**KIRKLEES METROPOLITAN COUNCIL
INVESTMENT & REGENERATION SERVICE**

DELEGATED DECISION TO DETERMINE PLANNING APPLICATIONS

Reference No:	2023/62/92928/E
Site Address:	Land at, Taylor Hall Lane, Mirfield, WF14
Description:	Erection of 4 dwellings
Recommending Officer:	Nicole Helliwell

Officer Report

3 First Floor Layout
Scale: 1:50

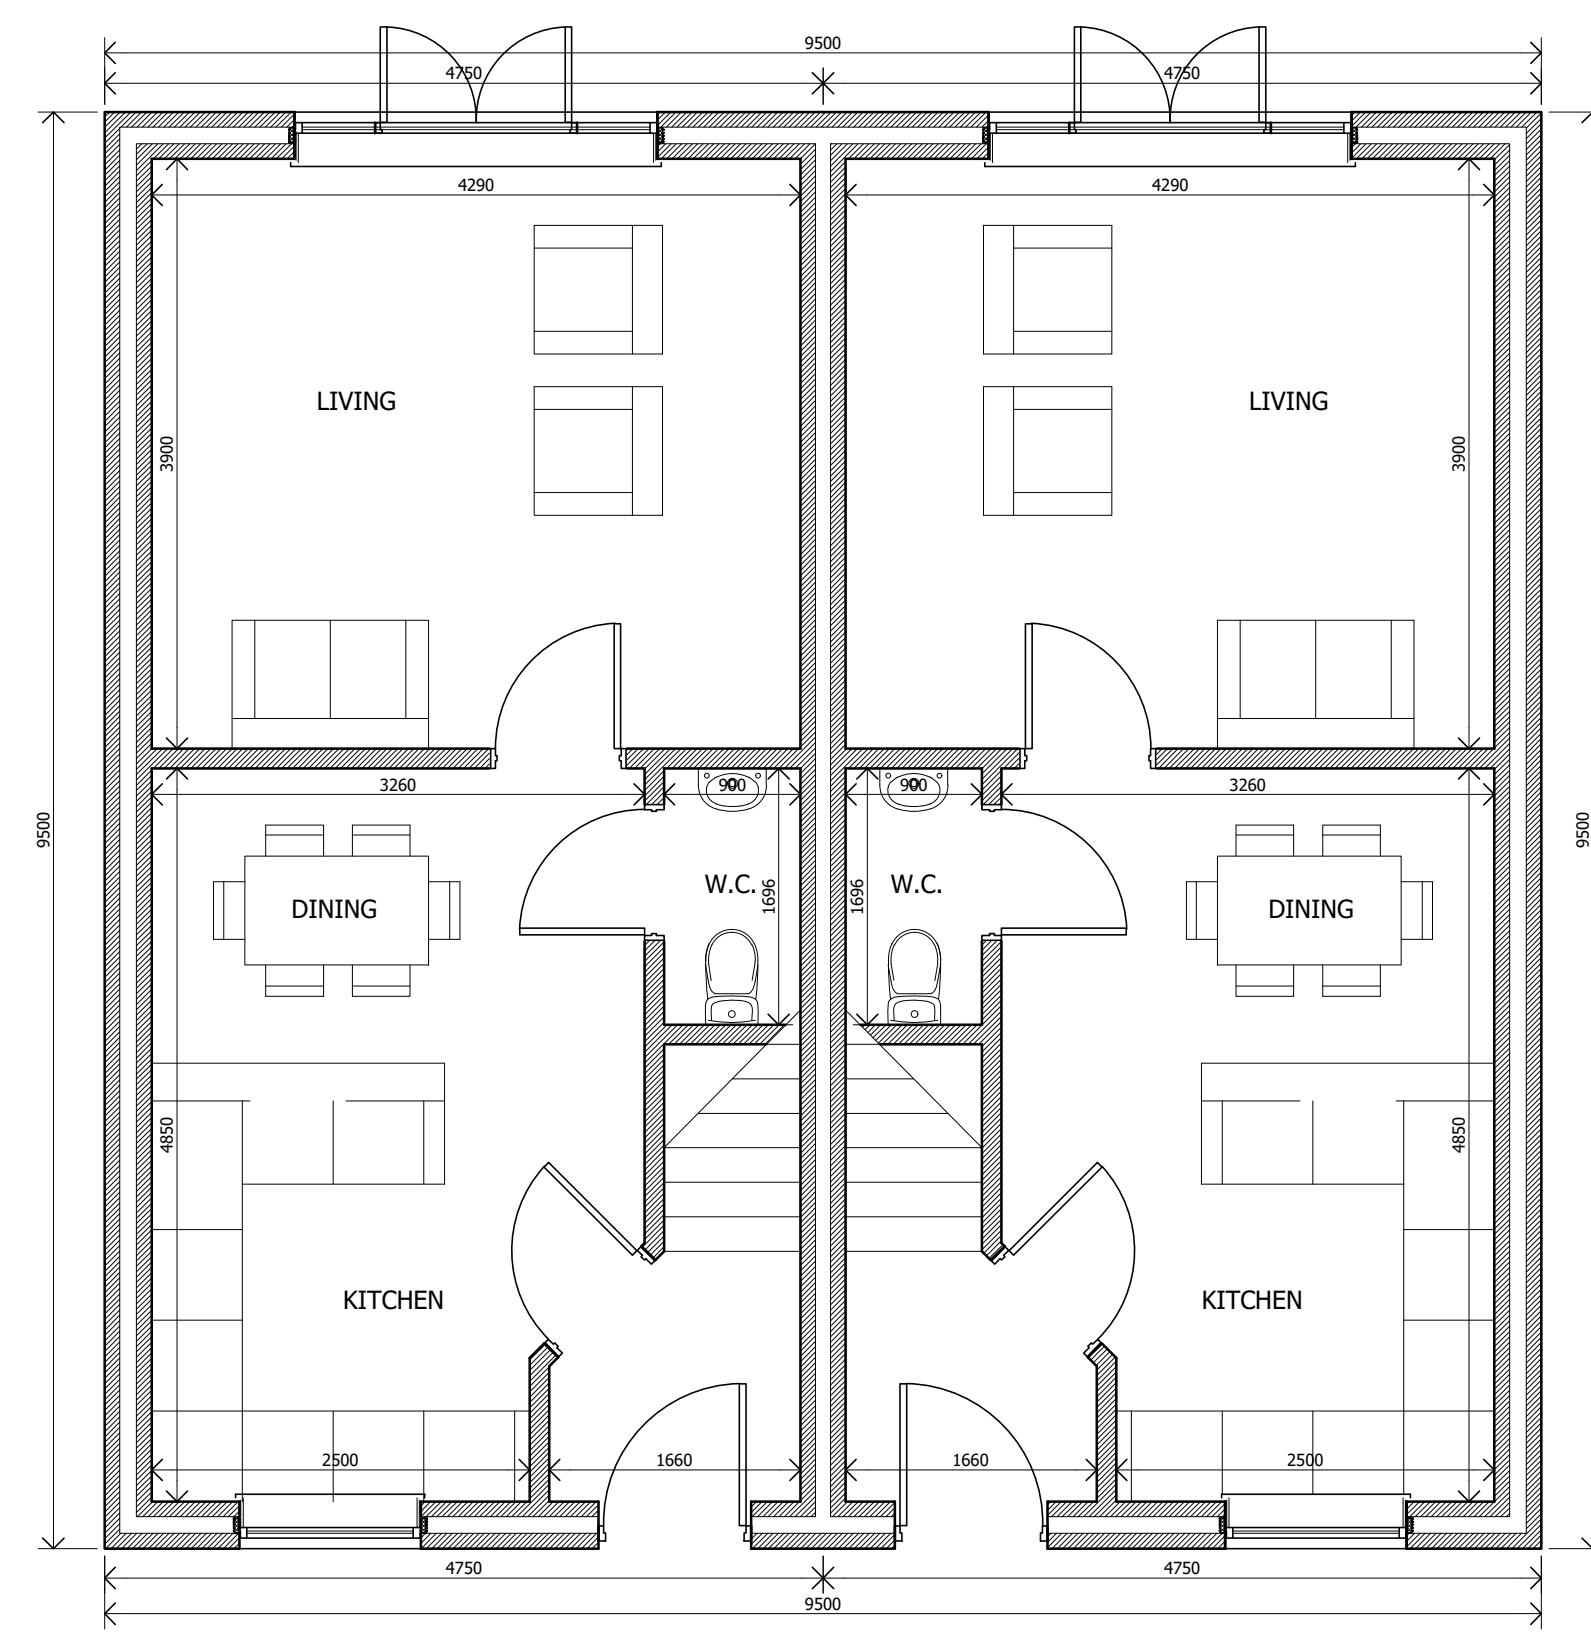
The proposed floor plans show that the properties would have three bedrooms and therefore are required to have a minimum internal floor space of 99m². The dwellings are shown to have an internal floor space of 102.7m², which would adequately meet basic lifestyle needs and provide a high standard of amenity for future occupiers. It is also noted that each of the habitable rooms would benefit from a sufficient amount of natural light. Furthermore, private outdoor amenity spaces are proposed to the rear of the properties and areas of off road parking are proposed to the front of the site. For these reasons, it is considered that the proposal would provide an acceptable standard of living for future occupants and would accord with LP24(b) of the Kirklees Local Plan, Principles 6 and 16 of the Council's Housebuilders Design Guide SPD, and Paragraph 135(f) of the National Planning Policy Framework.

Amendments were sought during the course of the application. Concerns were raised regarding the internal floor space of the dwellings as they failed to accord with the nationally described space standards. Revised drawings were received which were considered acceptable in terms of residential amenity.
